M42 Junction 6 Development Consent Order

8.8(b) Statement of Common Ground with Solihull Metropolitan Borough Council

STATEMENT OF COMMON GROUND
Solihull Metropolitan Borough Council

Version	Date	Status of Version
2	Sept 2019	Updated Draft for Deadline 4 Submission

Drawing Title  
**REVISED ACCESS ARRANGEMENTS FOR FOUR WINDS AND GAA**

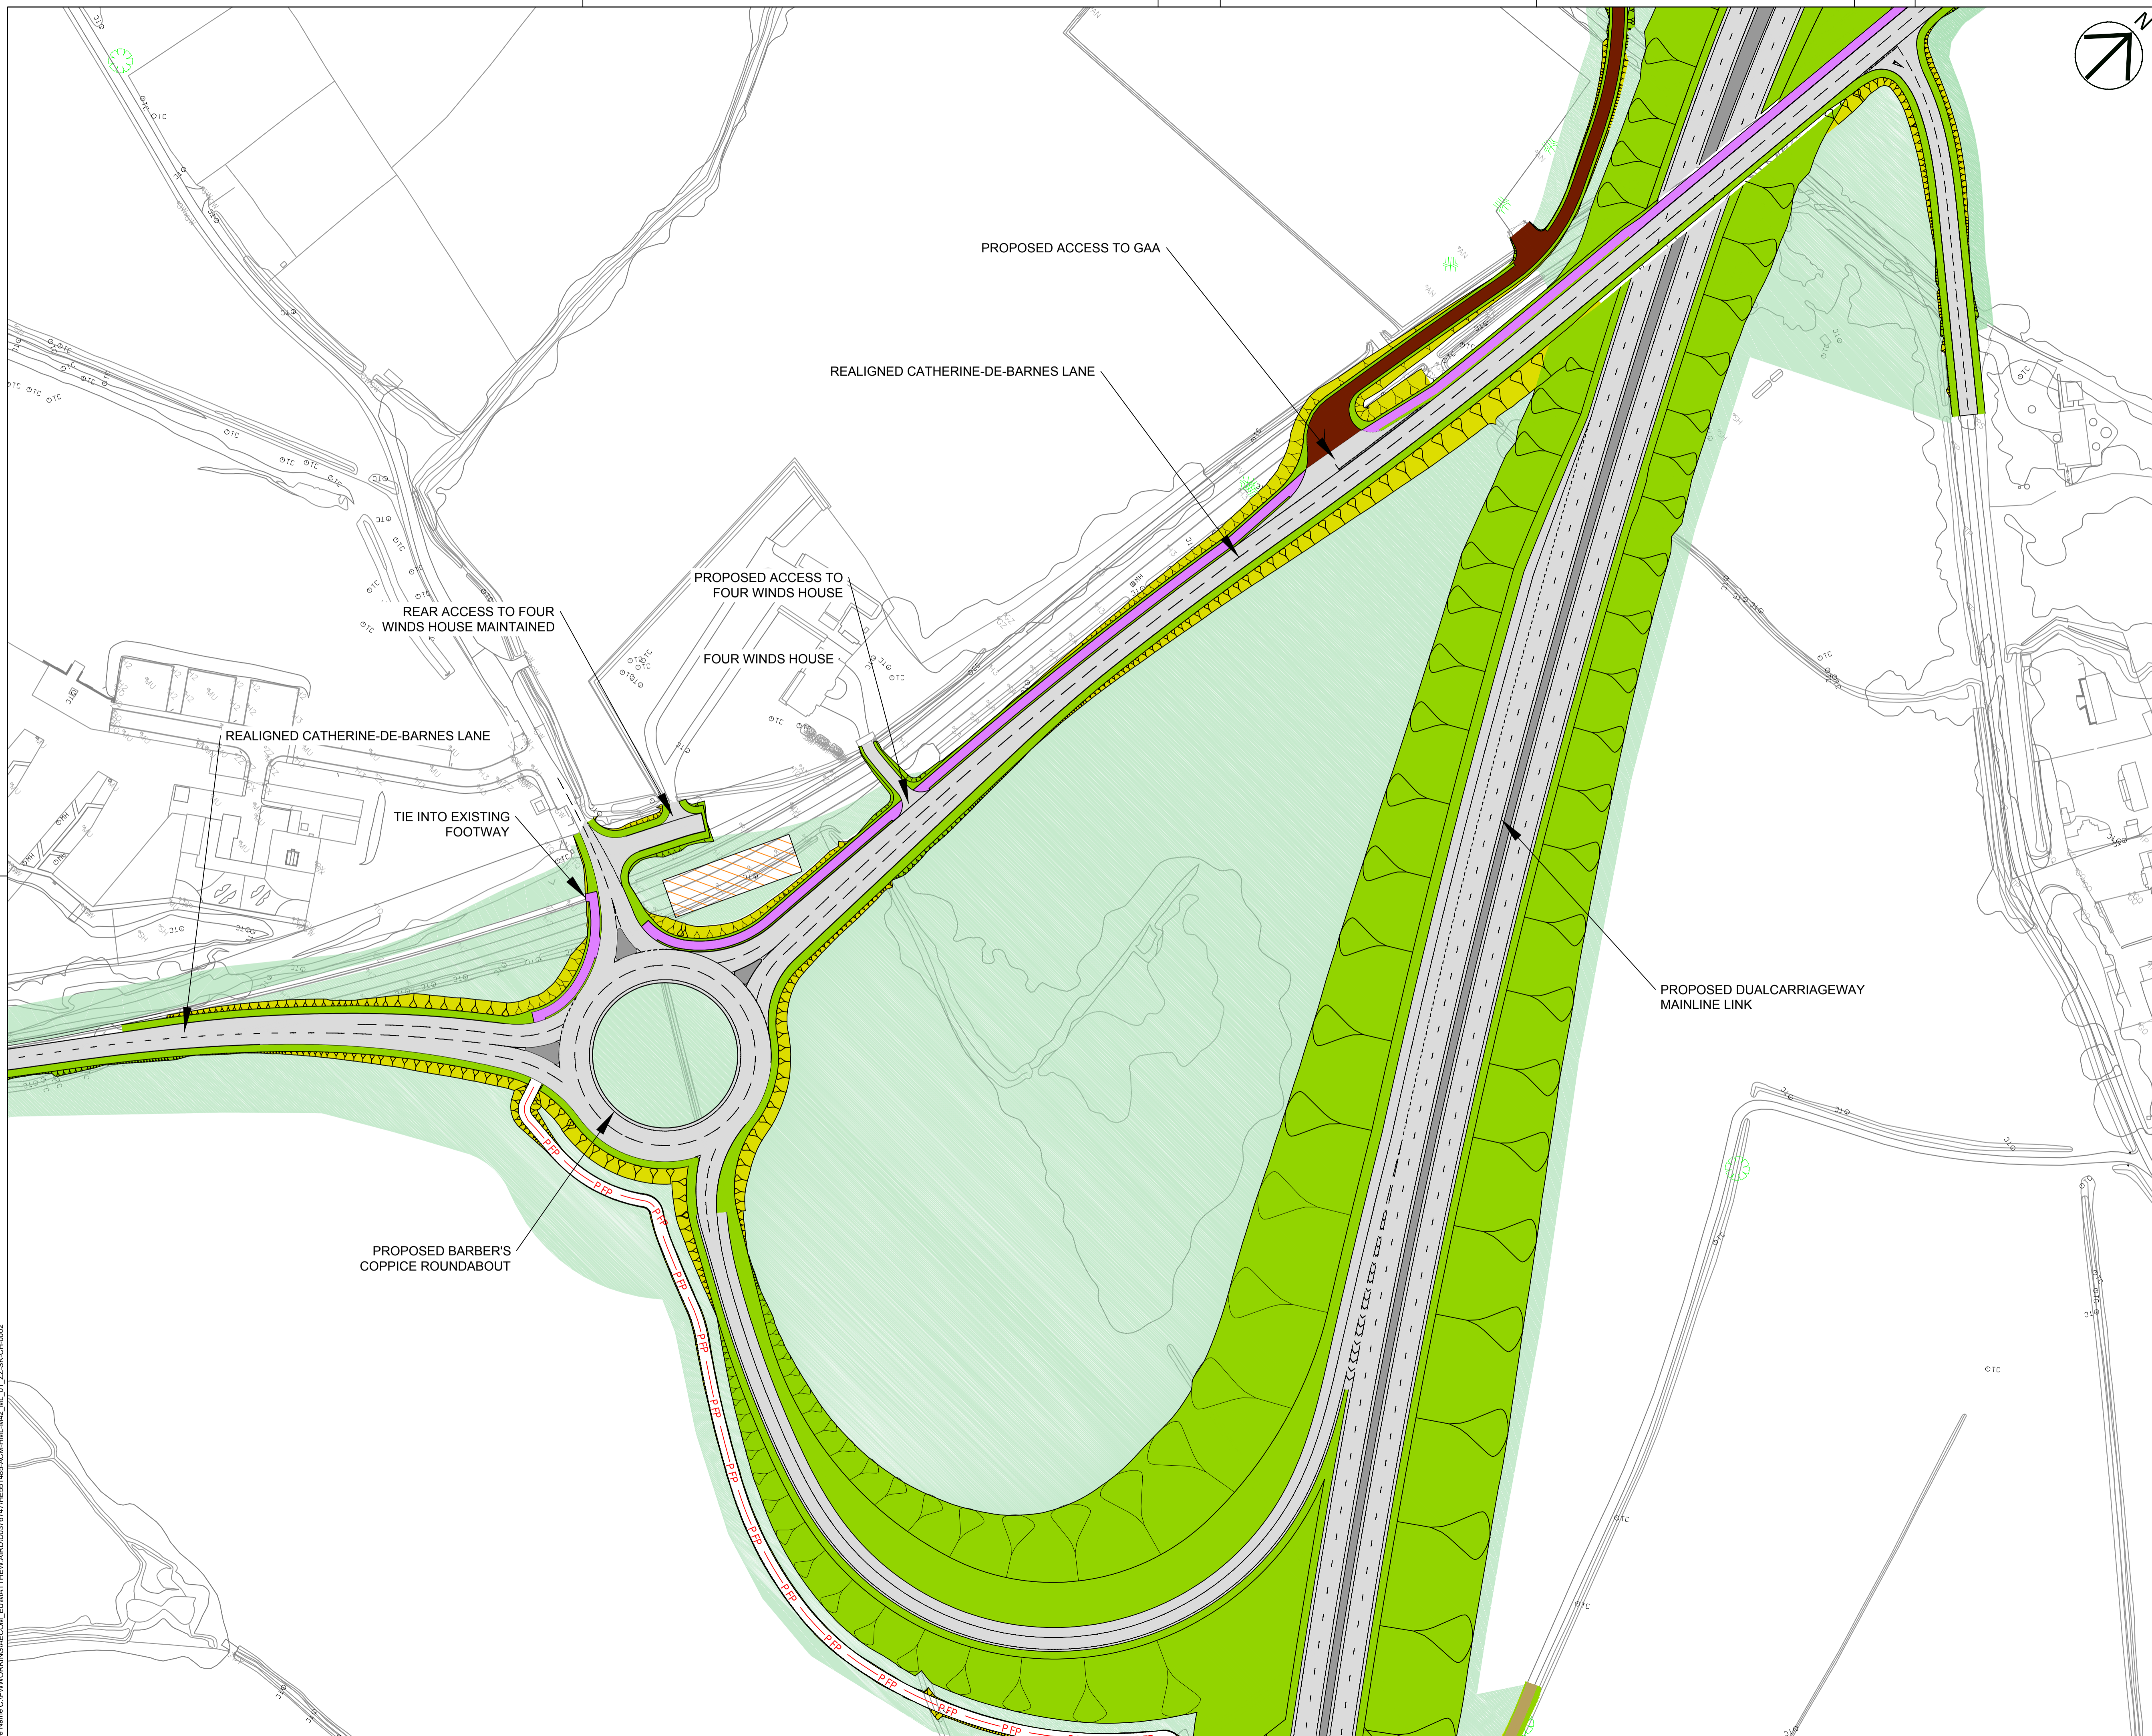
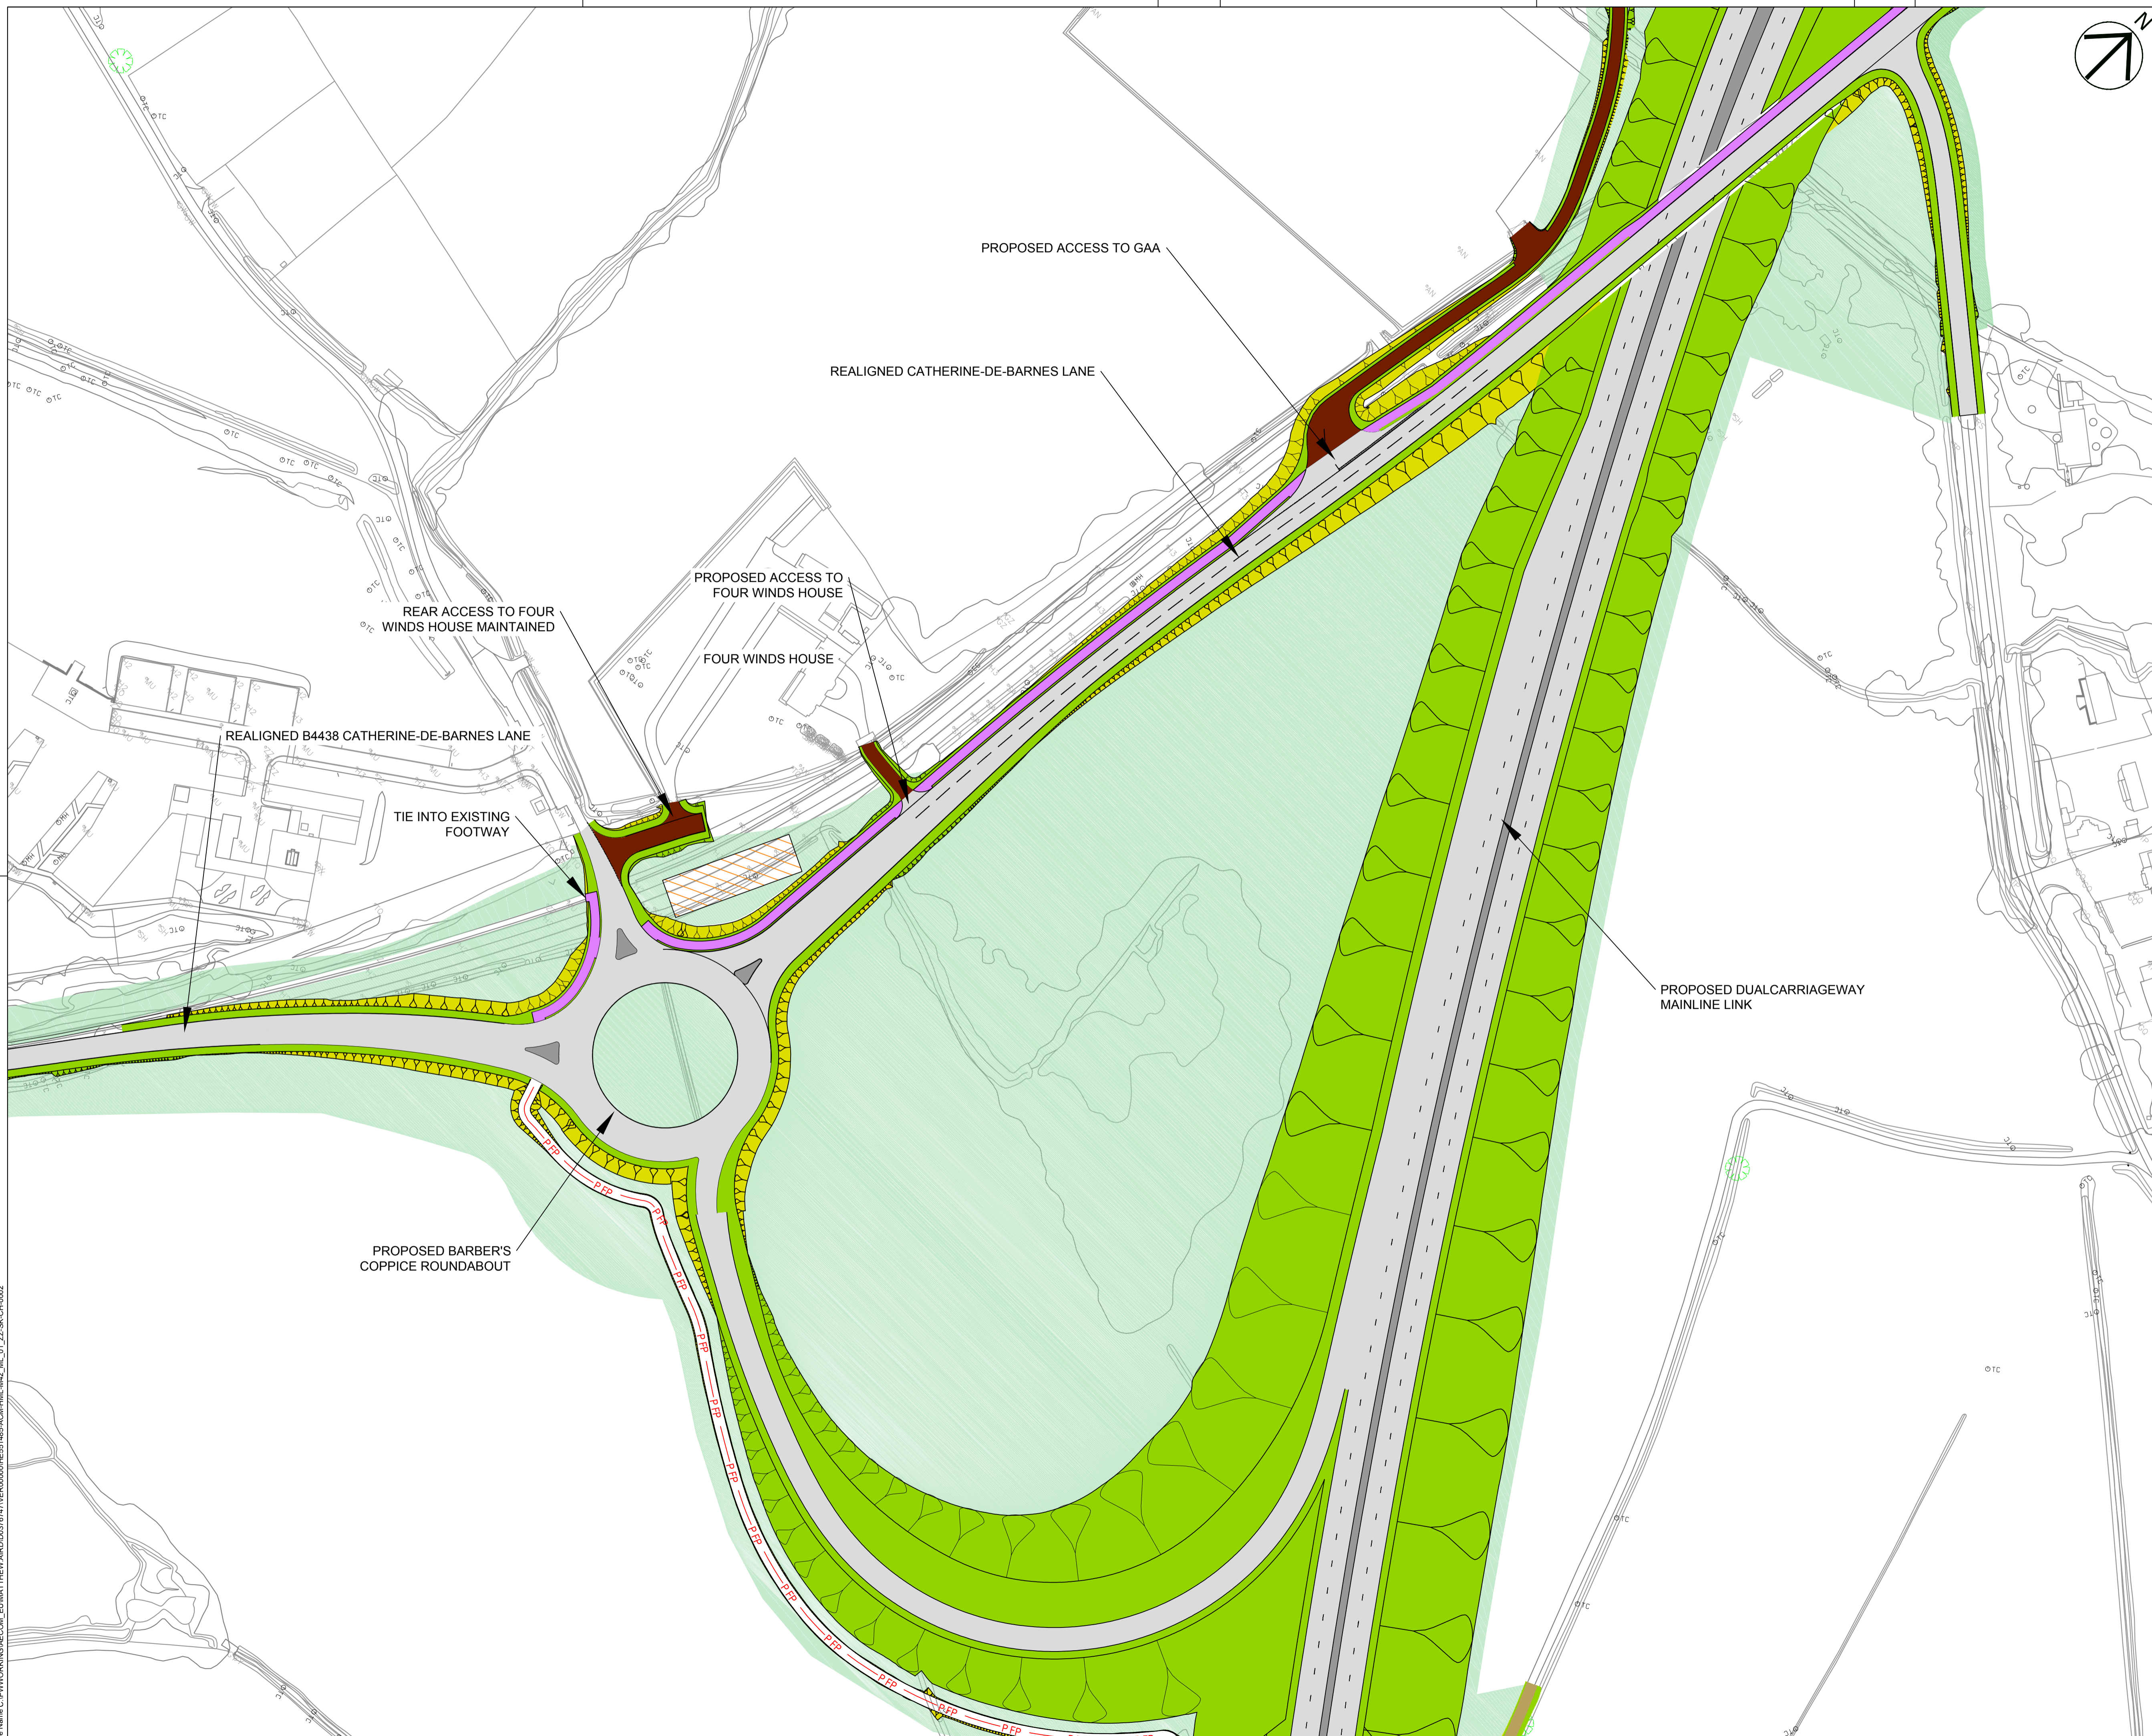
An alternative access is welcomed. Is there an alternative access to the WGAA, off Catherine-de-Barnes Lane, that would avoid a link past Four Winds?	<i>Highways England has developed a proposal for an alternative access for the WGAA within the Order Limits that has been discussed with SMBC. It was noted that this proposal is preferable to SMBC. Highways England will be putting this forward to the ExA as part of the more detailed proposals for the WGAA reconfiguration.</i>	Agreed
